Our reference: ECM: 9630965 Contact: Gavin Cherry Telephone: (02) 4732 8125

21 July 2021

# Response to Notice of Exhibition: Proposed Westlink Industrial Estate SSD-9138102

# Aldington Road Frontage

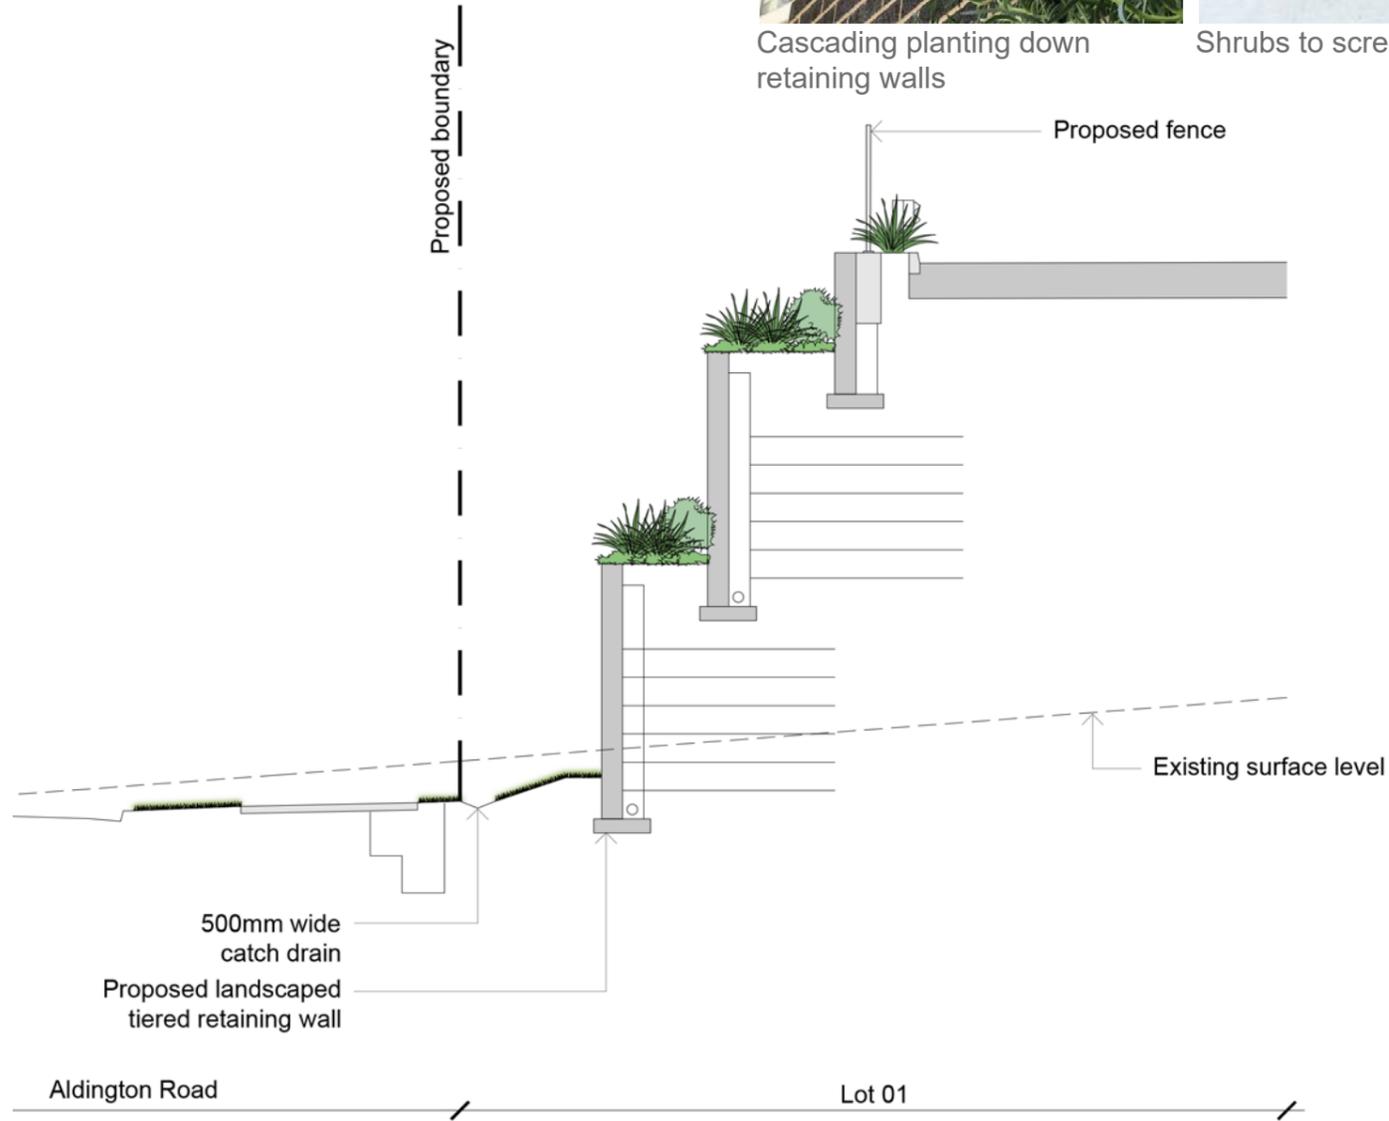
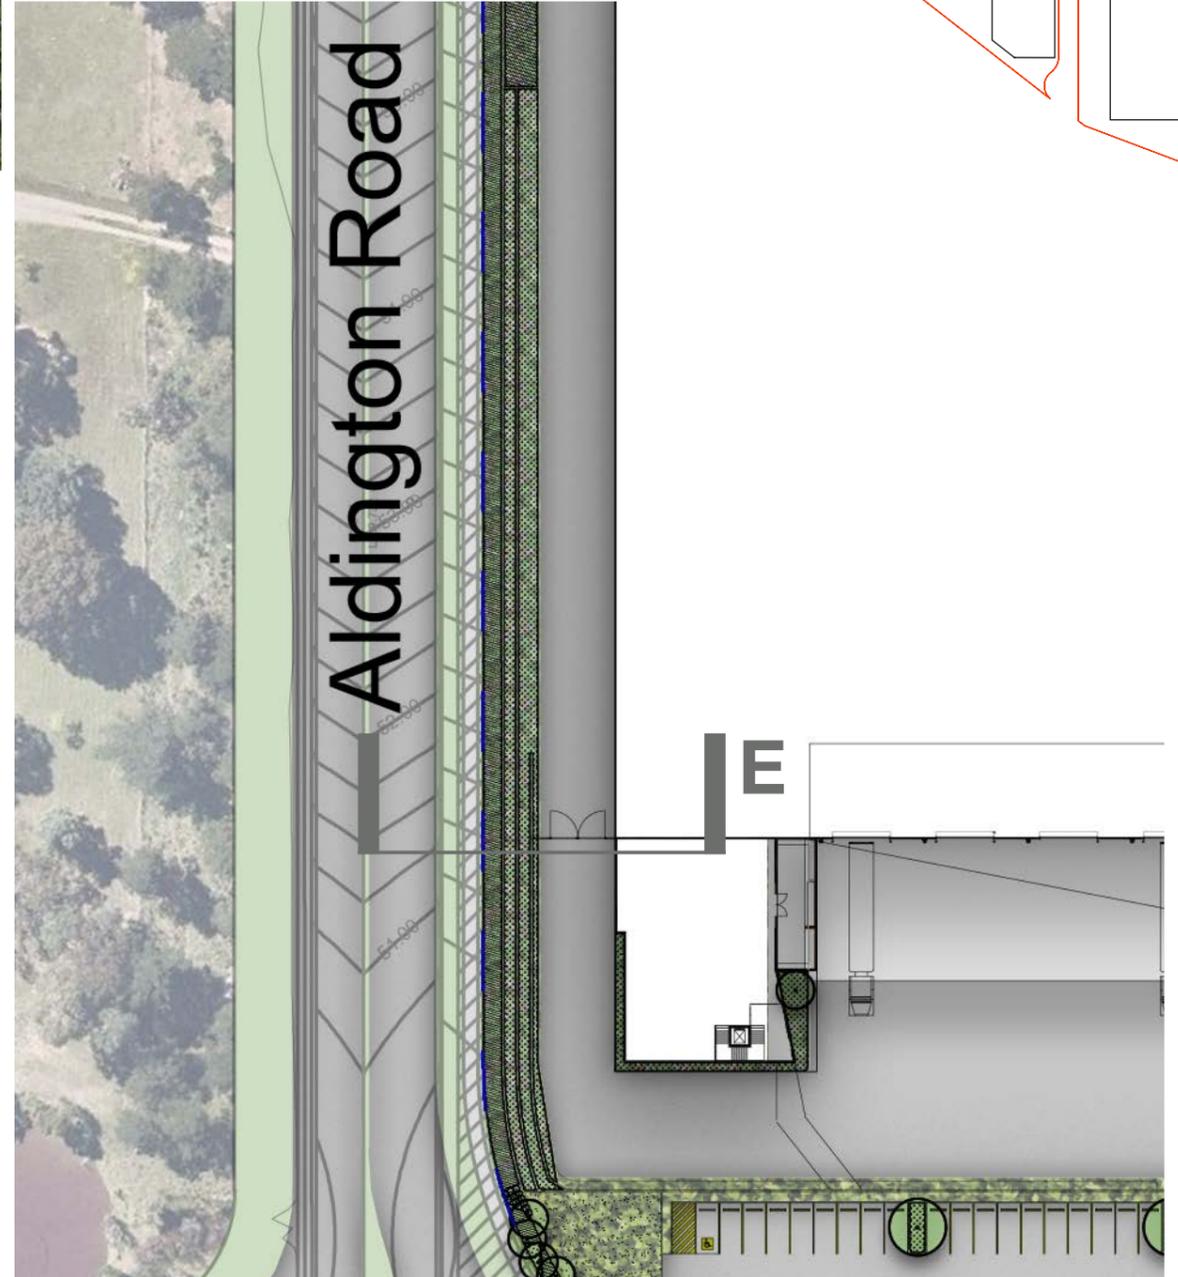
- The proposal does not comply with the above objective and controls as follows :-
  - The stepped retaining wall associated with Lot 1 fronting Aldington Road appears to only be set back 500m and not the required 2.0m as per the DCP. Further, the 500mm accommodates a catchment drain (assumed to be a swale) which will compromise any potential for screen landscaping in front of the first retaining wall tier. While the retaining wall (effectively 7.4m in height as per section indications in the civil drawing package) is of a tiered design and landscaped at each tier which is appreciated, the setback at ground level is still important, especially when considering the pedestrian experience and streetscape presentation of the development to the roadway,.

- Carparks tree planting detail and tree species information is required to enable adequate assessment.
- Insufficient detail is provided for the Aldington Rd frontage, such as wall heights, species, materials. While one (1) x section drawing was evident within the civiil drawing package for the Aldington road treatment, the landscape design plans have no corresponding sections and require spot levels and top of wall heights to assess the impact of the proposed levels with respect to landscaping. The applicant is requested to provide detail to scale and with dimensions. All wall surfaces should be screened with planting, including the lowest wall. Tall trees & canopy are required to the streetscape and verge

Warehouse 3

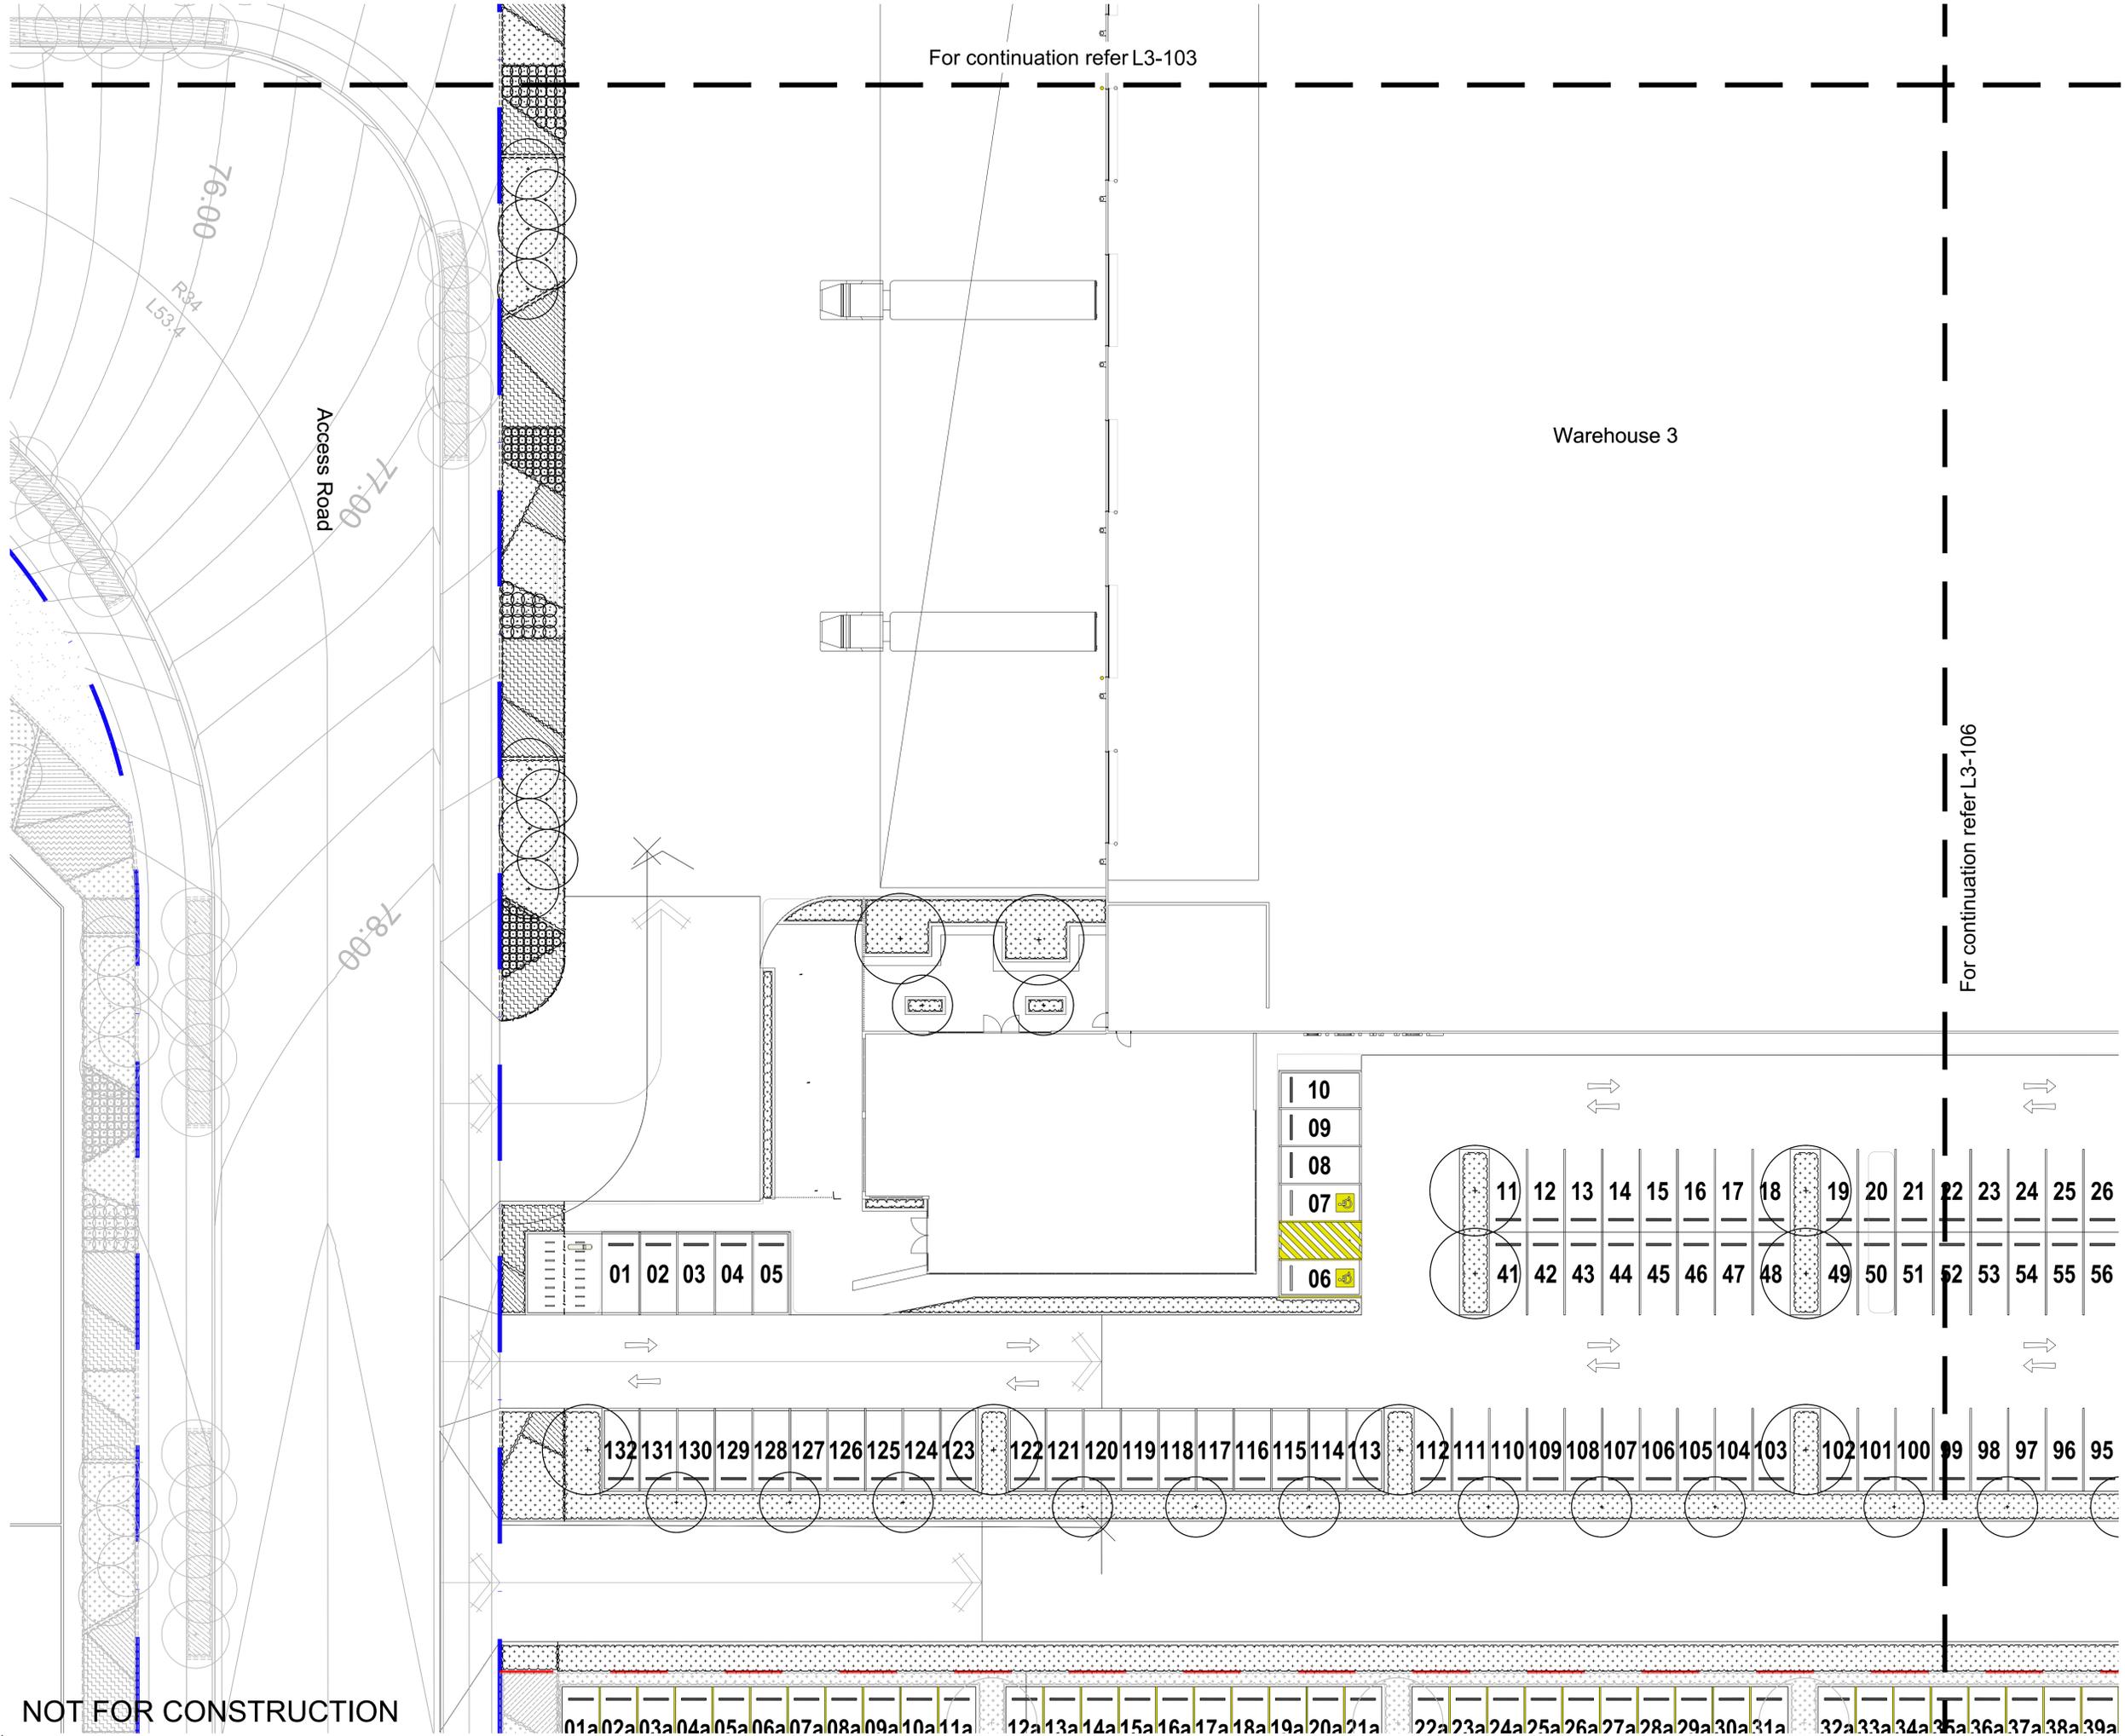
- Warehouse 3: With respect to the west boundary additional tree planting should be included within the landscape design.
- Opportunities exist for canopy plantings in several areas around the estate, both large and small which are currently proposed as turf. This should be reconsidered,
